City of Portland, Maine - Building or Use Permit Application

Permit No: 05-1601	Issue Date: 111512005	CBL: 087 Z031001
-----------------------	--------------------------	---------------------

Proposed Use: Single Family w/Home Occupation- Build an 18' x 24' barn w/an 11' x 8' Shed & 8' x 17' deck	Proposed Project Description: Home Occupation/build an 18' x 24' barn w/an 11' x 8' Shed & 8' x 17' deck
--	---

Dept: Building Status: Approved with Conditions Reviewer: Jeanine Bourke Approval Date: 11/15/2005

2 STORAGE LOFT PLAN
1/4\"/>

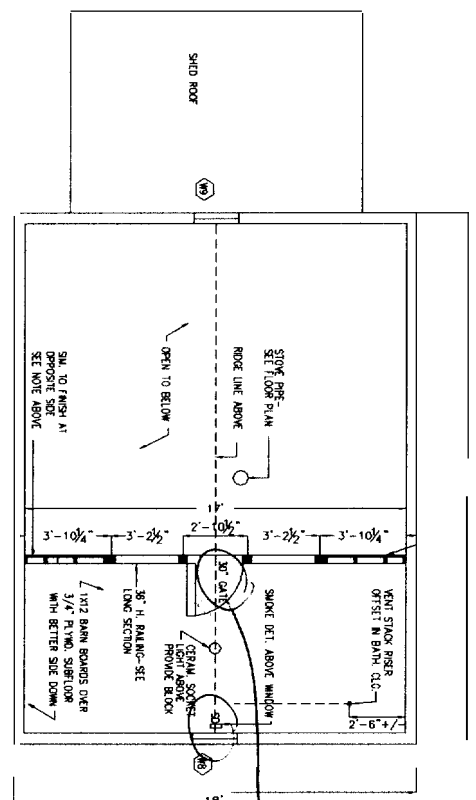
- 1) As discussed, the gate to the loft area is not required as it is to be used solely for storage and not to be a habitable space. Permanent stairs or ladders are NOT to be installed.
- 2) Separate permits are required for any electrical, plumbing, or heating.
- 3) Application approval based upon information provided by applicant. Any deviation from approved plans requires separate review and approval prior to work.
